PLANNING

Planning application 3/2023/0252: 1 Kirkbeck Mews, Bolton by Bowland

Existing Ground Floor Plan / Site Plan  
1:100 Scale

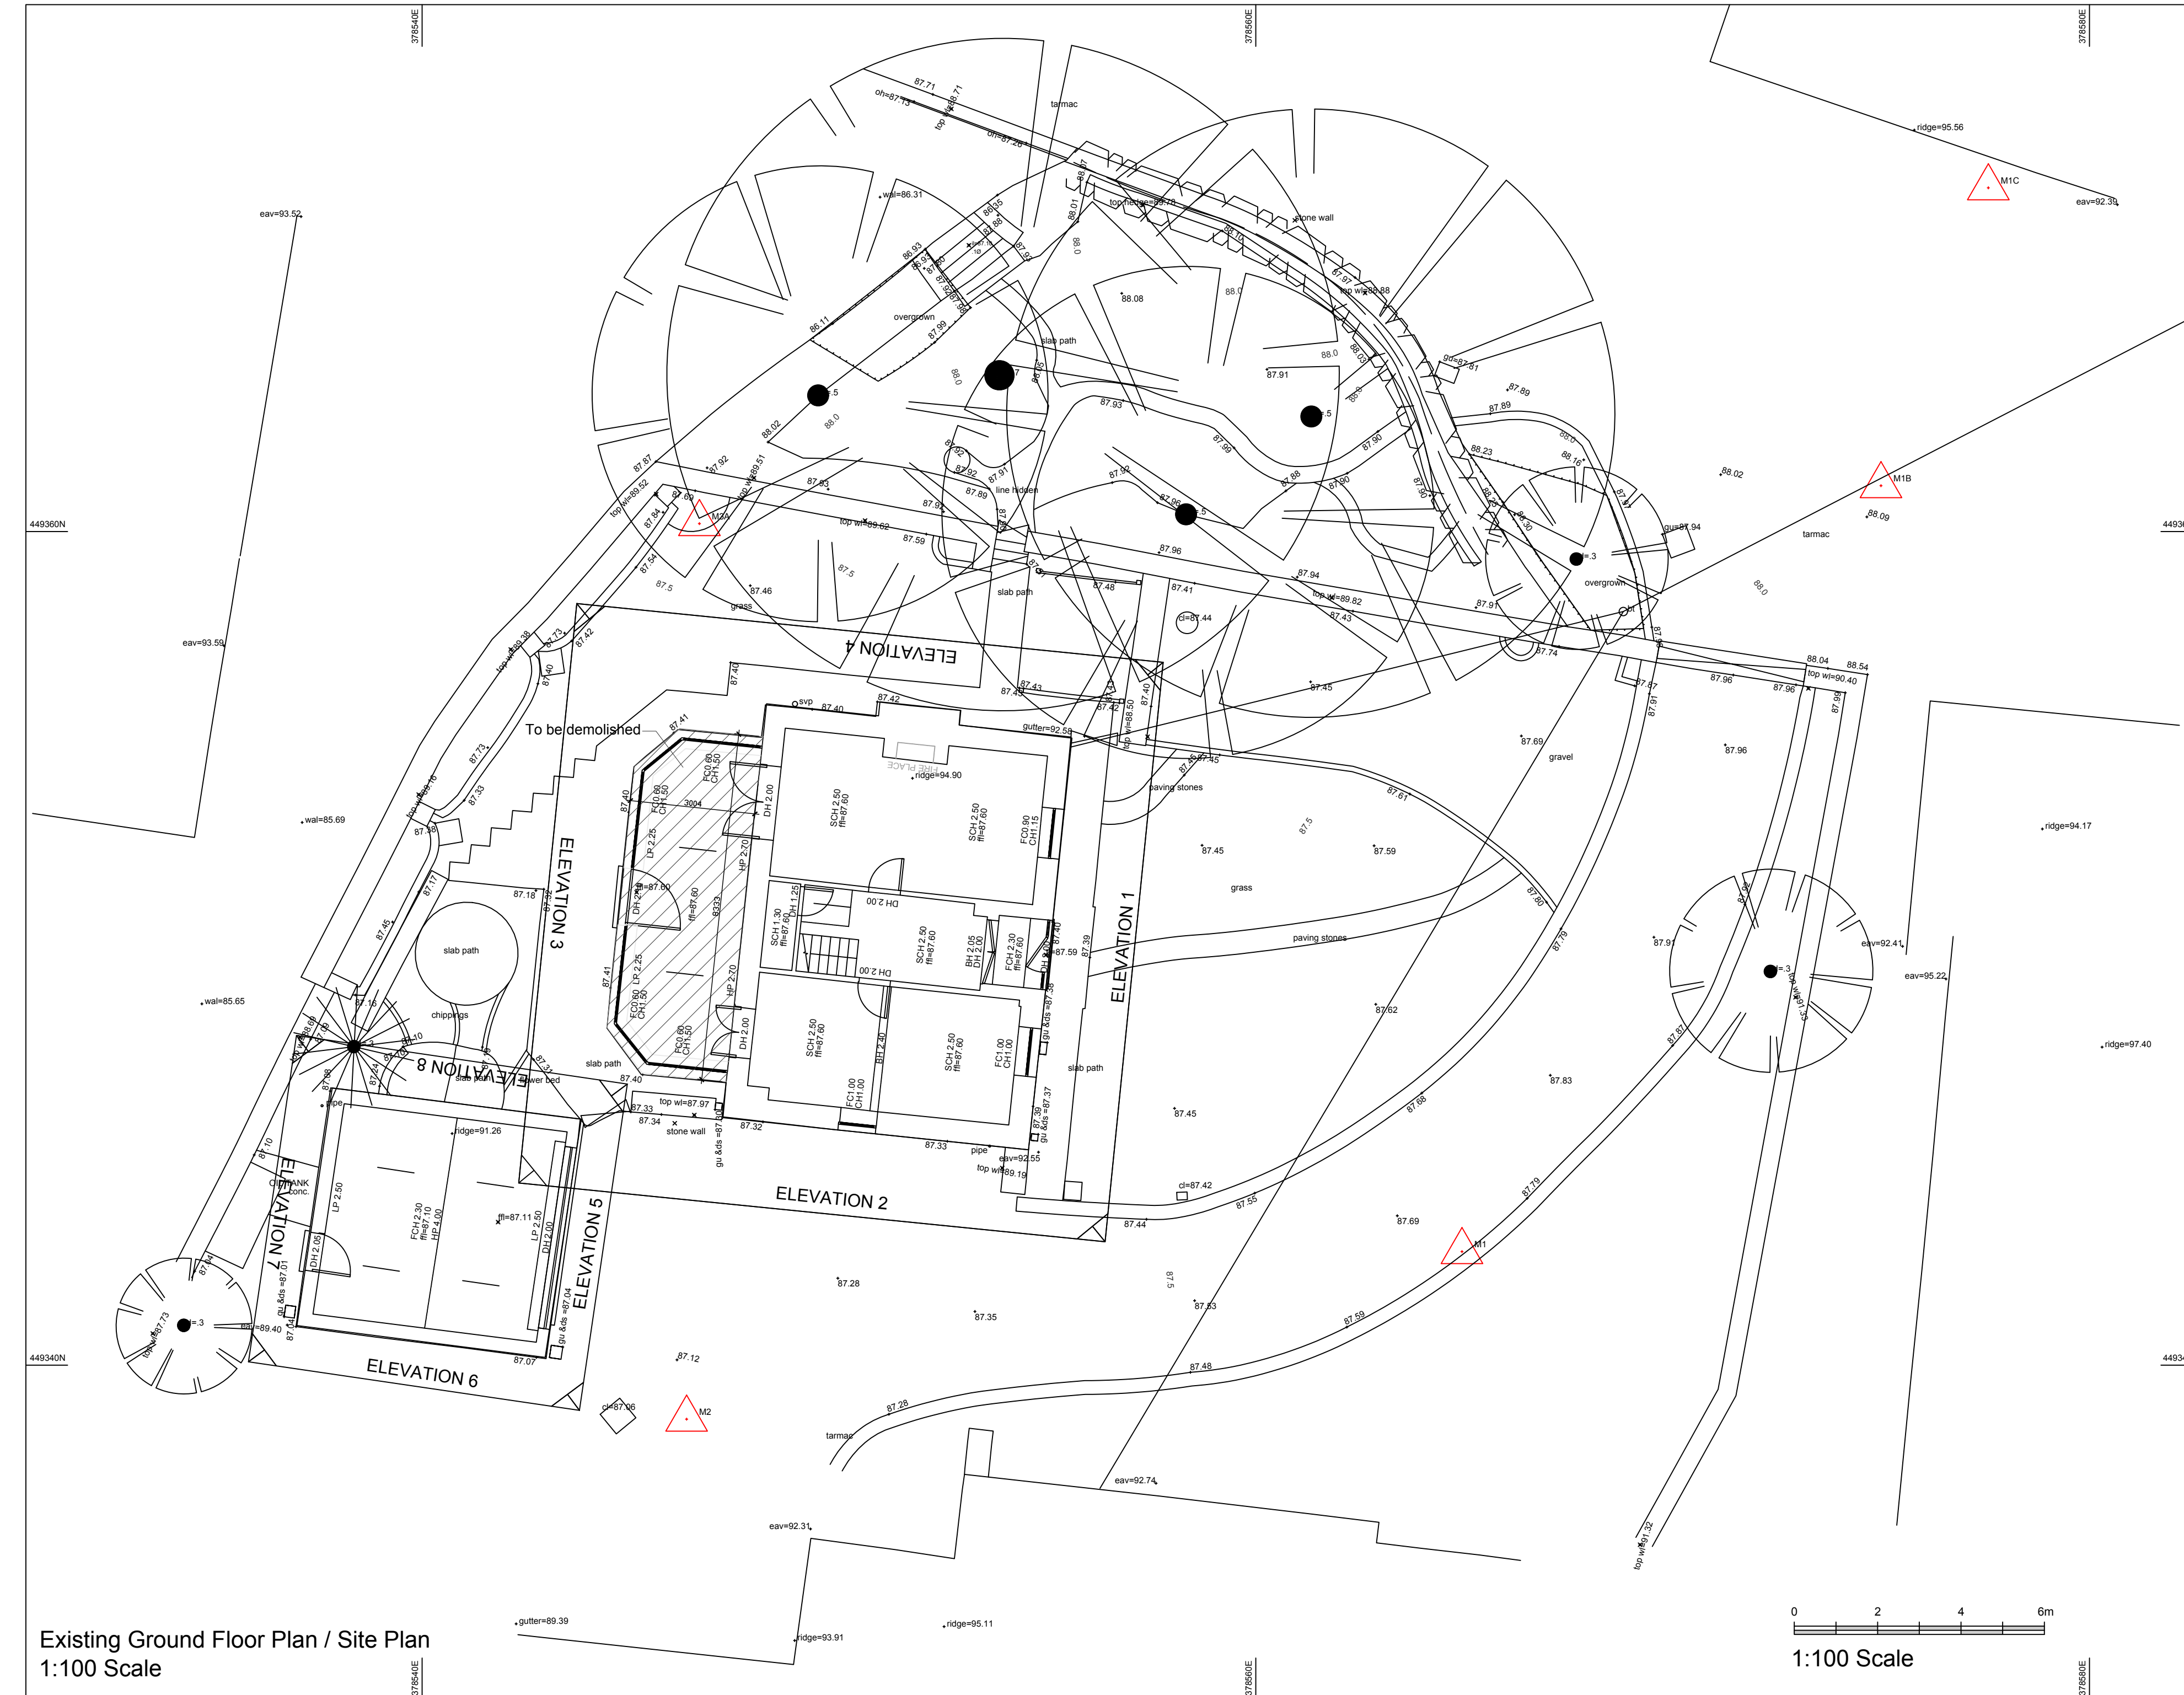
The 'red line' indicating land owned by 1 Kirkbeck Mews omits a parcel of land; bounded by the red line, the road and the stream.

Proposed Floor Plan / Site
1:50 Scale

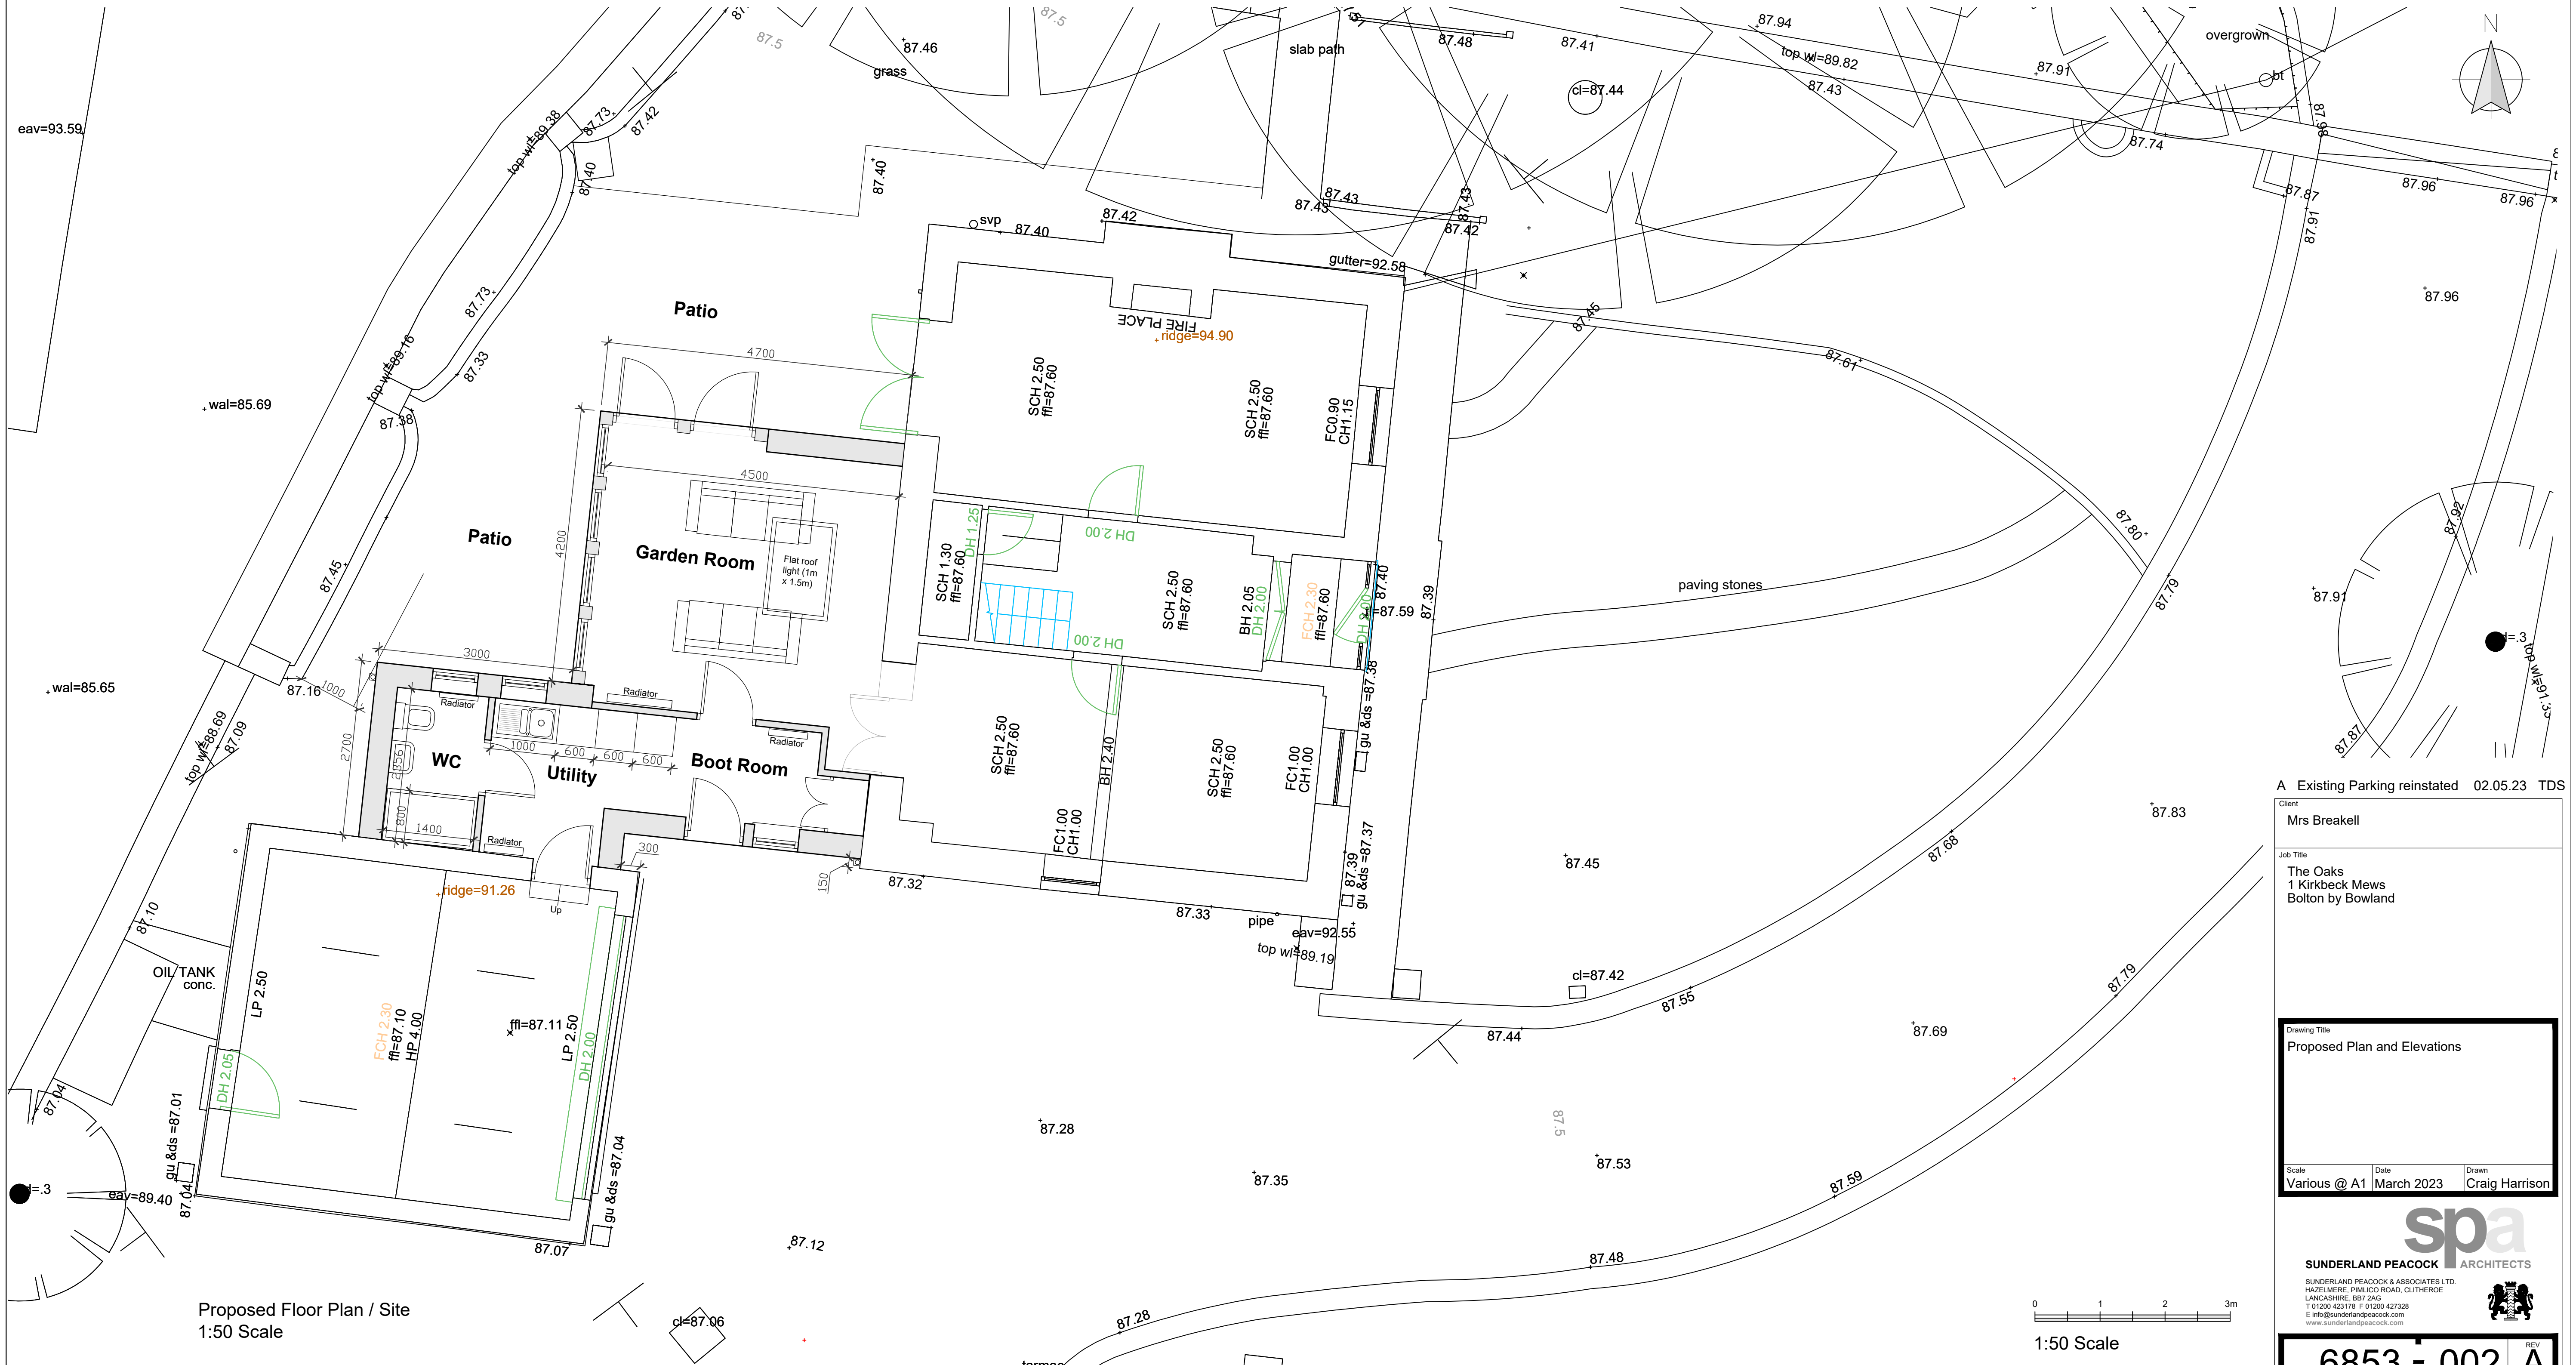
The application states new or altered vehicle access from the public highway is required but without clarification and is not shown on the drawings. The access for 1 Kirkbeck Mews has always been from, and appears to remain from, the private drive (off the public highway) number 1 has a right of way.

The application states the existing car parking arrangements* will be affected but how is not made clear from the submission. Additional parking arrangements are stated to be provided but without clarification or detail. This could be in direct contradiction to the various deeds and documents relating to the area in front of the two houses, to which each house owner is a signatory, dating from 1996/7. Currently each house has a double garage and three additional car parking spaces.
